National Grid Electricity Transmission plc (National Grid) – The National Grid Yorkshire Green Energy Enablement (GREEN) Project – EN020024

Notification of Applicant's Intention to Submit a Request for Proposed Changes to the DCO Application

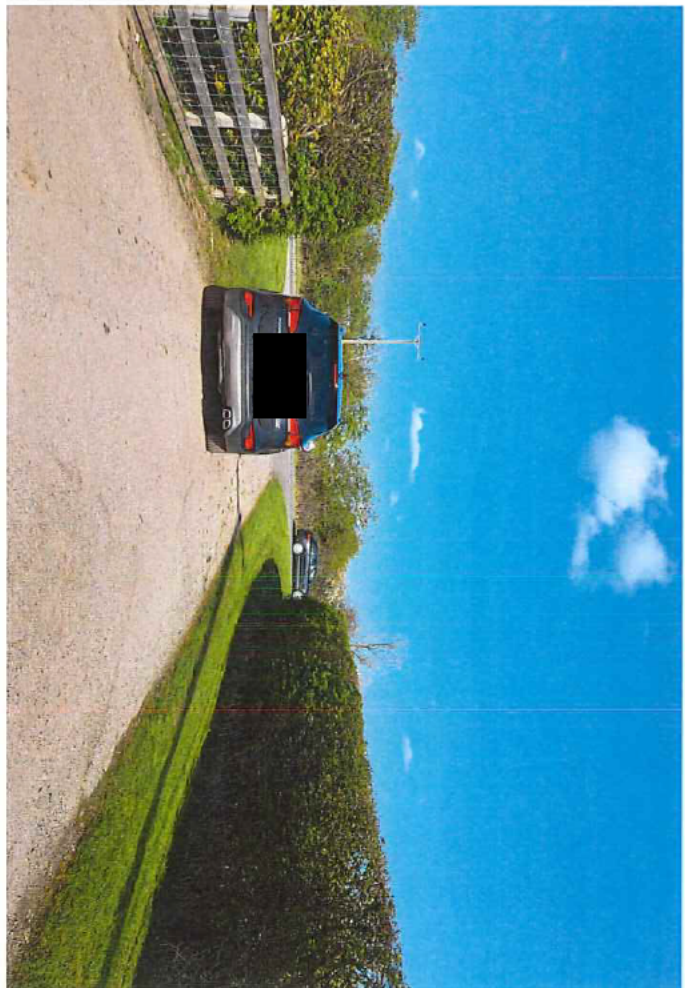
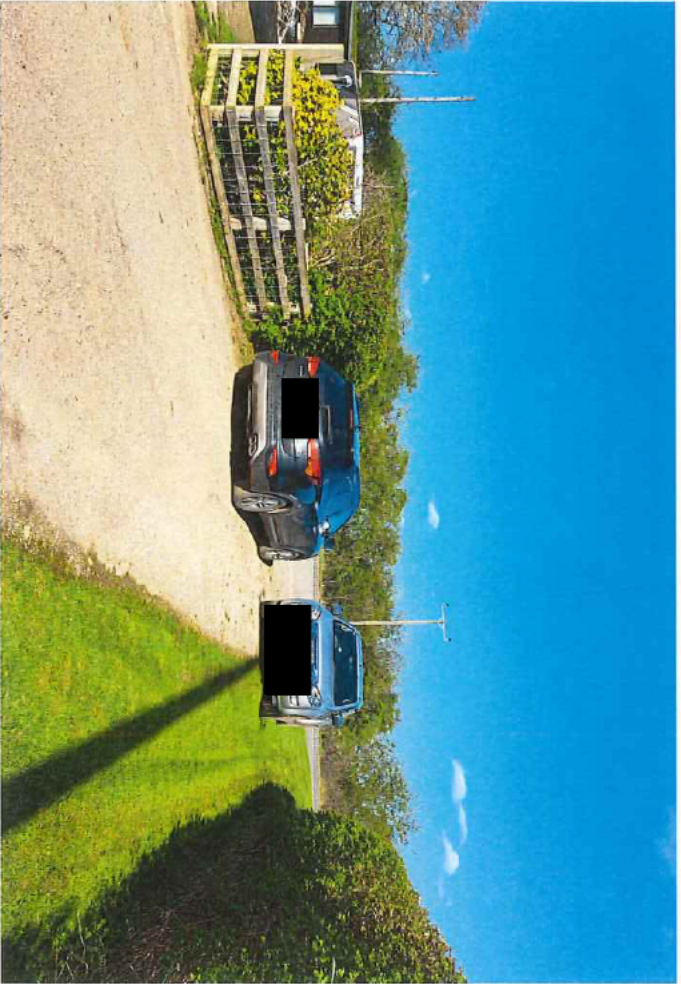
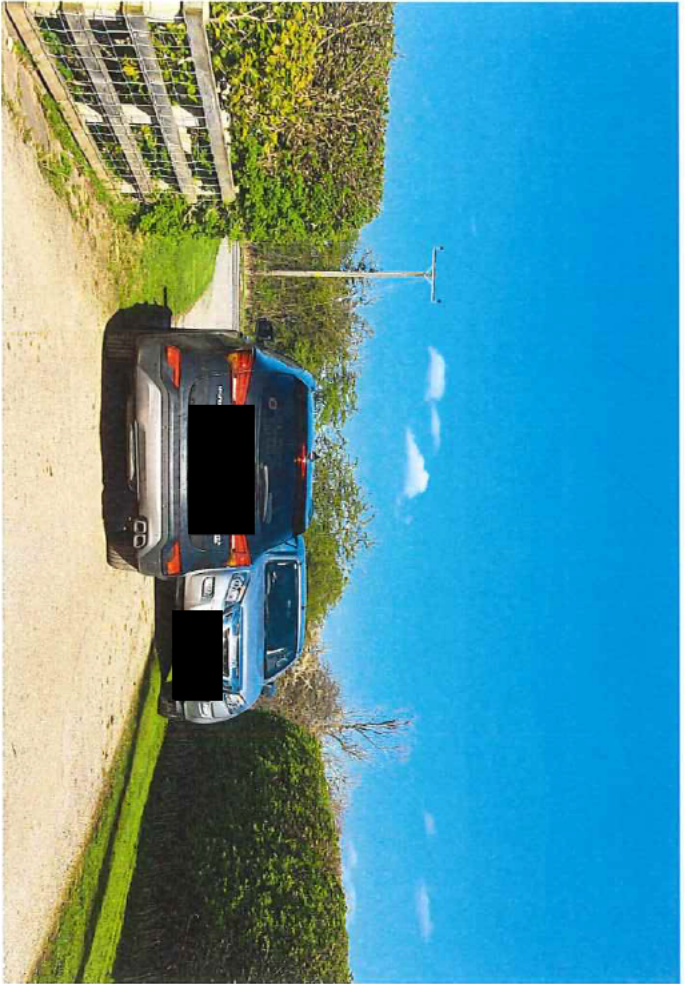
Change 2 – New Farm Cottage Access

This change would alter the construction access point and redirect the construction access route (save in respect of the construction of a temporary watercourse crossing) through existing land within the Order limits. It would prevent the need for utilities diversion 'U4' to take place but would necessitate an additional temporary watercourse crossing. Construction access past New Farm Cottages would be retained to allow vehicles access to construct the temporary watercourse crossing only. In addition, operational access past New Farm Cottages would also be retained for maintenance purposes.

## **Annex 3F.1.C Shipton CSEC Access Point**

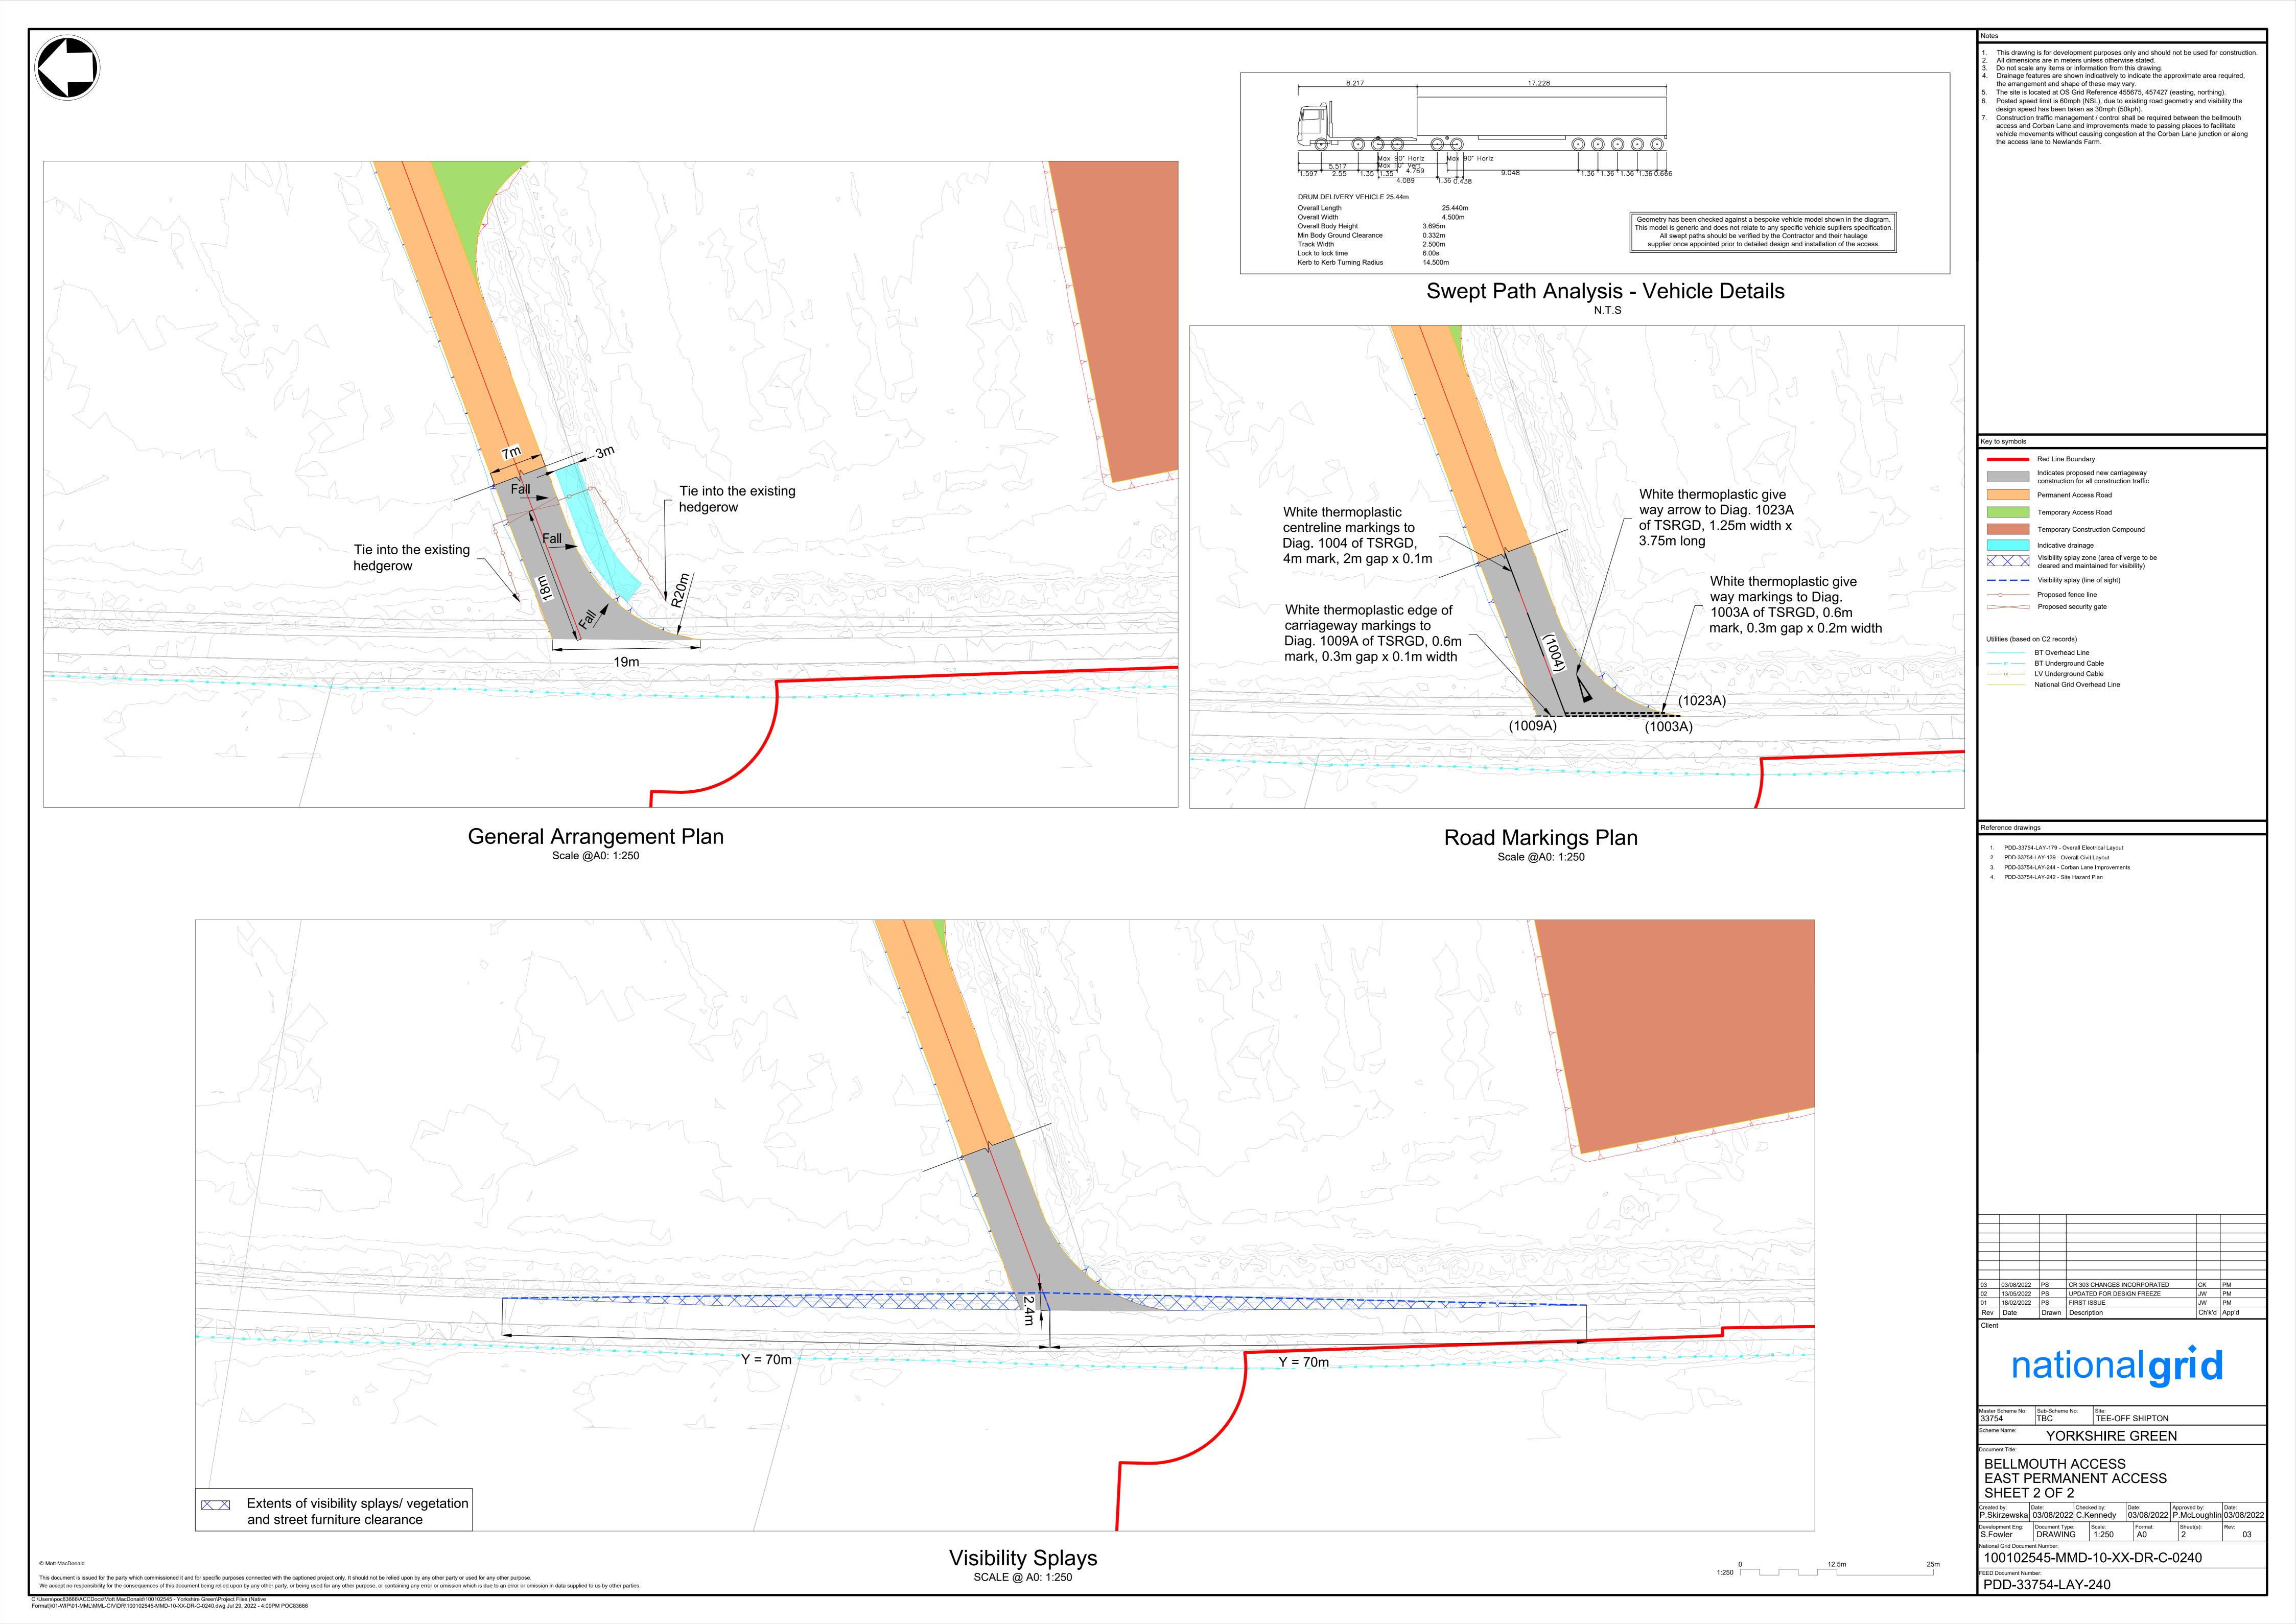
Change 3 – Shipton Cable Sealing End Compound (CSEC) Access

This change is in the same location as the Shipton North Reduction (Change 1) but the two changes are not interrelated. The change would be to straighten the access and move the bellmouth northwards adjoining the highway (but still within the Order limits) as requested in representations made by the landowner's agent at the Accompanied Site Visit and at the Hearings.
